To: **Greater London Authority (Transport for London Comments)**  
From: **Iceni Projects**  
Date: **19/06/2024**  
Title: **Post Submission Comments for 3 The Square, Furzeground Way, Stockley Park, Hillingdon**

I write to provide a response to the statutory consultee comments received from *Transport for London* (TfL) dated 28<sup>th</sup> May 2024 within the Greater London Authority Planning Report (GLA/2024/0149/S1/01) response in relation to the proposed development at 3 The Square, Furzeground Way, Stockley Park, Hillingdon (*London Borough of Hillingdon planning application ref. 57328/APP/2024/345*).

*“Change of use of existing office building (Use Class E) to a post-operative care facility (Use Class C2), including external works to the building, landscaping, parking, and all associated works”*.

Indicative Floor Plans
Site

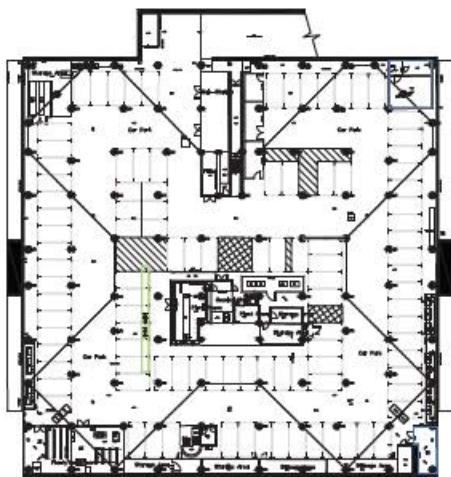
<p><b><u>Cycle Parking</u></b></p> <p><b><i>46 cycle parking spaces (includes both short-stay and long-stay), which take the form of Sheffield stands, are proposed, the quantum of which adheres to London Plan cycle parking standards T5. Whilst TfL supports the provision of Sheffield stands, the stands should be secured, covered and be design in line with the London Cycle Design Standards (LCDS). Long-stay cycle parking is located within the car park, and it is questioned whether it will be safe, convenient, and attractive for its intended users. It is strongly suggested that the Long stay cycle parking should be located within the basement. Within the LCDS part 8.3.1. it is stated that long-stay cycle parking is best located in a building, for example in a basement parking area, provided the entrance is well overlooked and well lit. Access needs to be considered carefully, particularly for those using non-standard cycles, with clear signing from the main entrance of the building to the parking area. It is recommended that external doors are a minimum of 2 metres wide. Further thought on the location of long-stay cycle parking is required.</i></b></p>	<p>It is noted that 46 cycle parking spaces is accepted by officers.</p> <p>The location is of the cycle parking will continue to be outside of the building and not within the basement as plant equipment and parking will be provided internal to the building.</p> <p>It is acknowledged that LCDS 8.3.1 states that long stay cycle parking is best located in a building, however it does go on to say that 'Where location in a building is not possible, bespoke shelters and lockers are an option, but consideration needs to be given to planning requirements. Cycle parking outside of buildings should be:</p> <ul style="list-style-type: none"> <li>• Sited in locations that are clearly visible and well overlooked with high levels of natural surveillance, and CCTV where necessary;</li> <li>• Designed with consideration of sight lines into and out of the cycle cages, compounds or secure store; and</li> <li>• Adequately lit and overlooked, particularly at night-time or where the parking is under cover.</li> </ul> <p>This will be considered as part of the detailed design process for the Site.</p> <p>Access will be considered relative to LCDS 8.2.1, and external doors will be a minimum of 2.0m wide.</p>
